**Consultation Response from KC,
Lead Local Flood Authority**

2024/90058 Penistone Road/, Rowley Lane, Fenay Bridge, Huddersfield, HD8 0JS

Date Responded: 5th June 2024

Condition 8 – Drainage Details

ENGINEERING FEASIBILITY LAYOUT

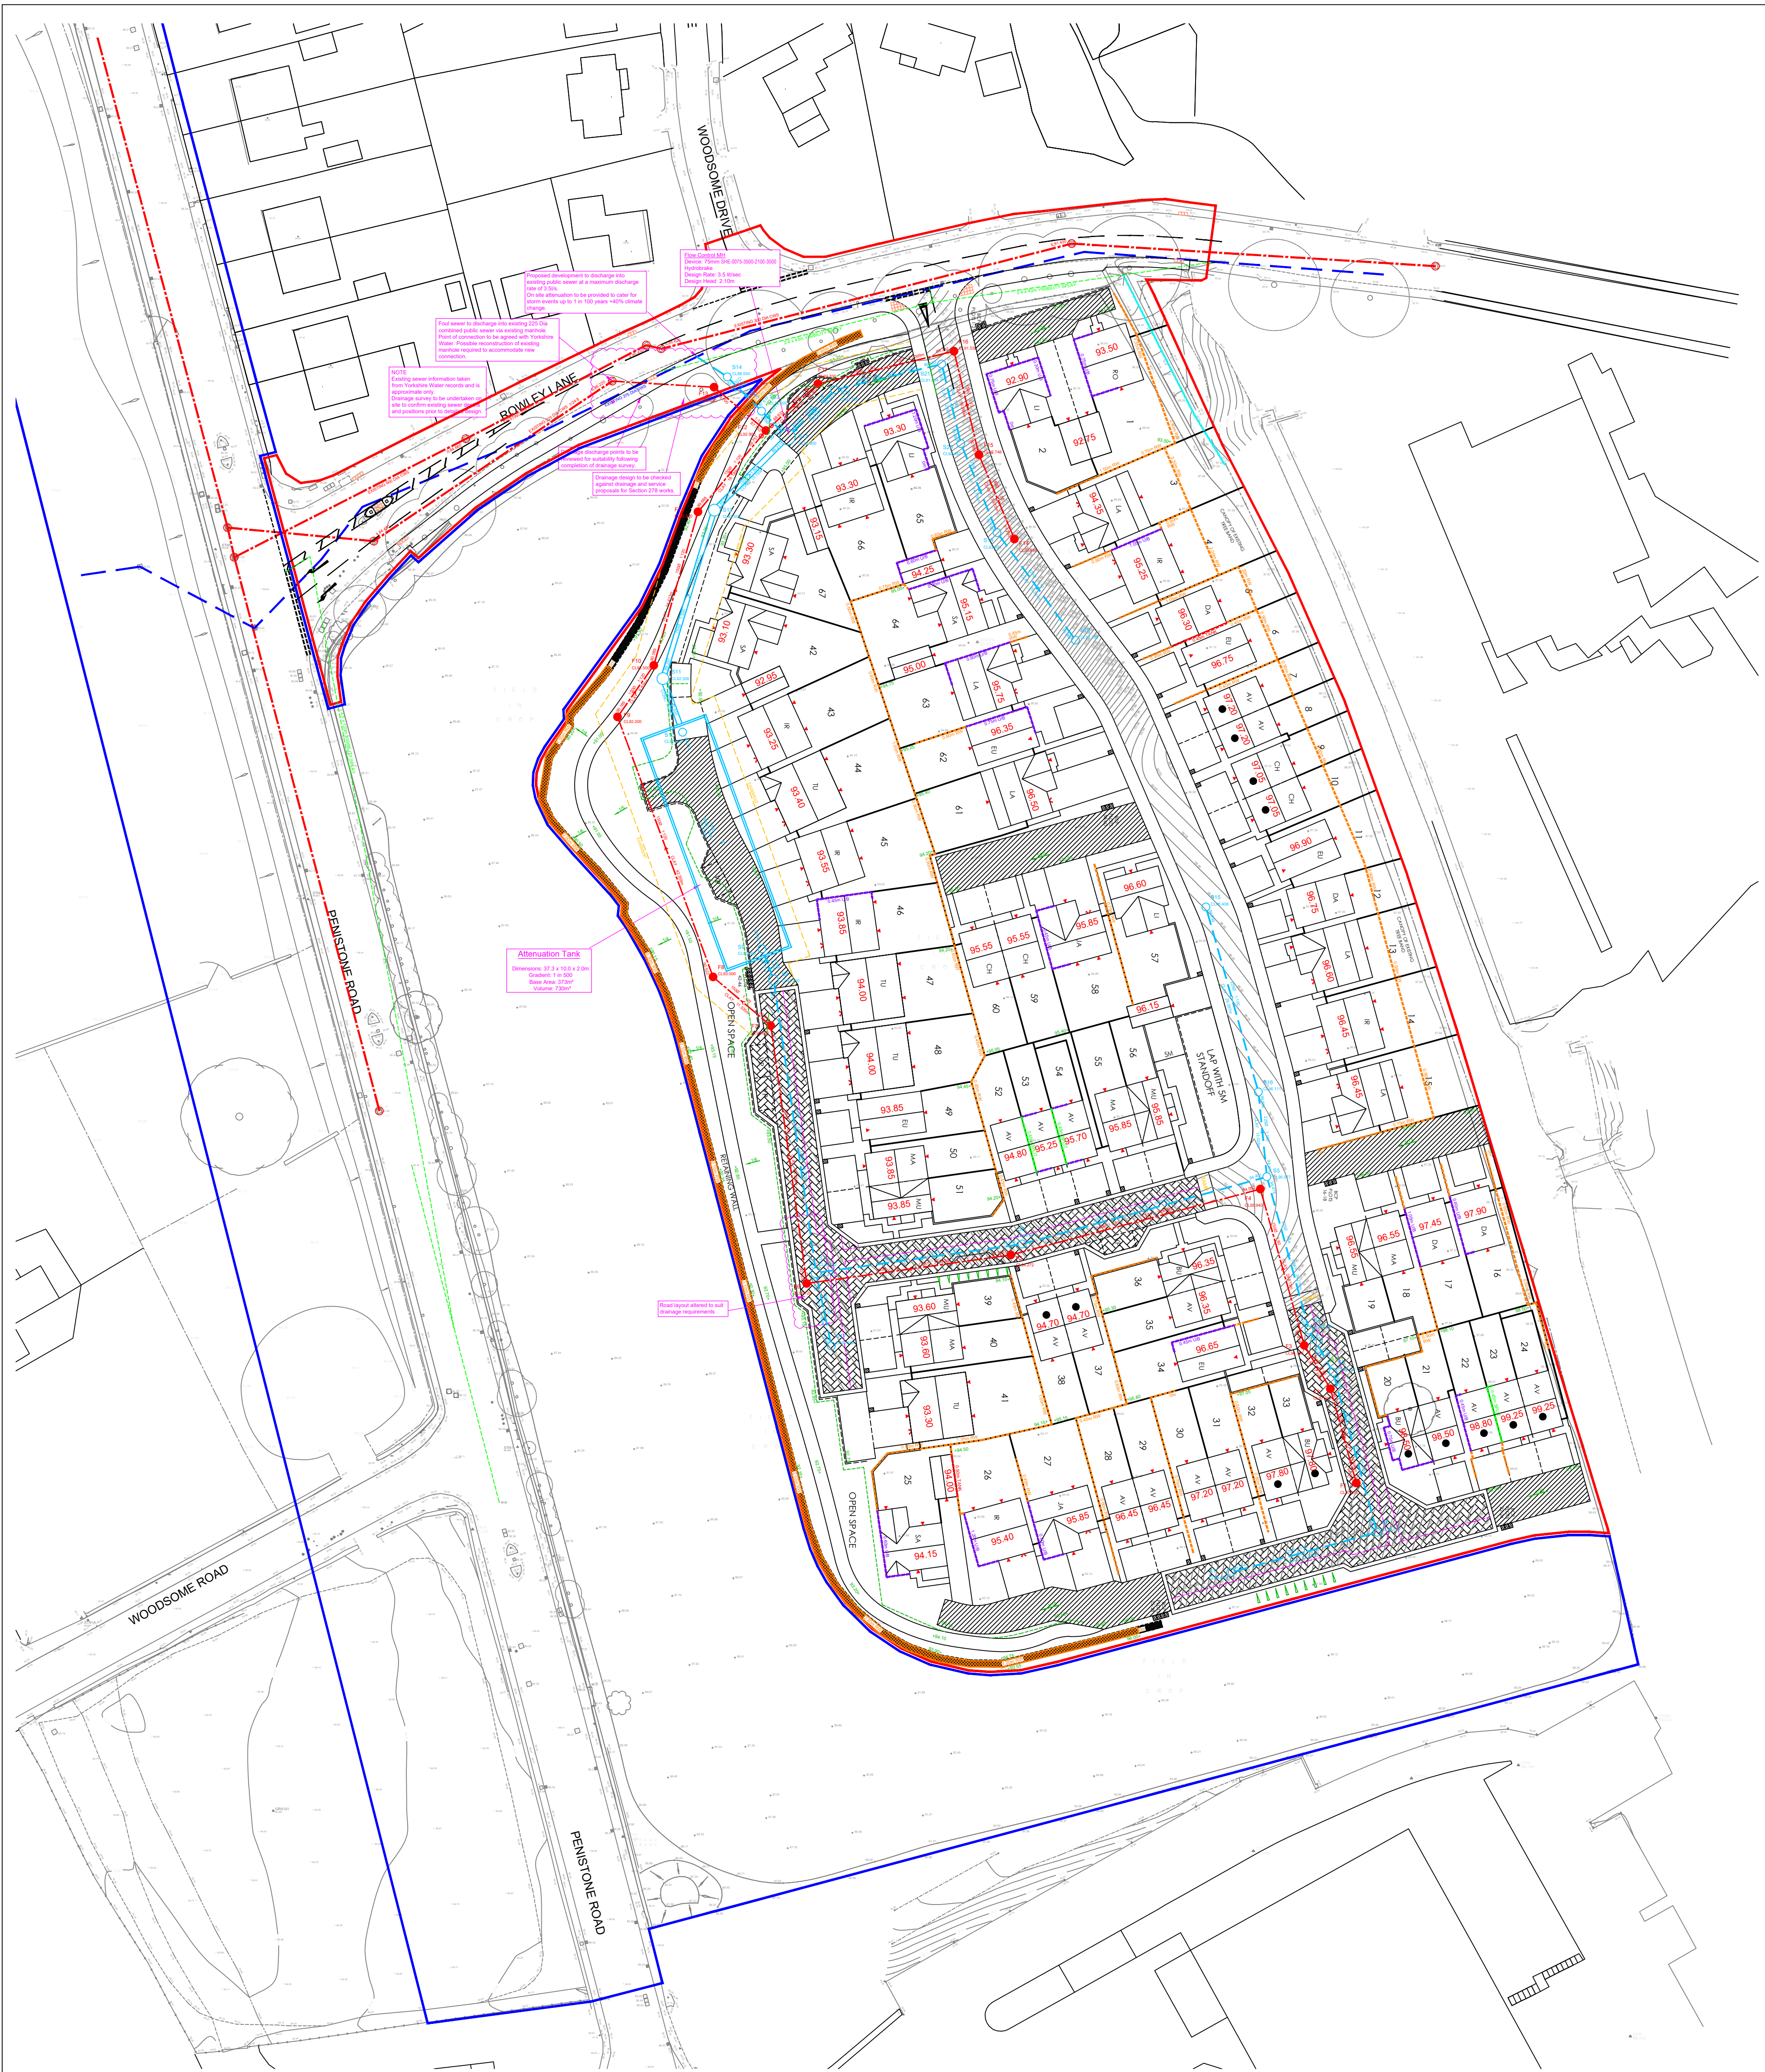
A cross section and plan drawings of specific tank design is required to match with the maintenance plans and be included as a supplementary appendix in the section 106 agreement.
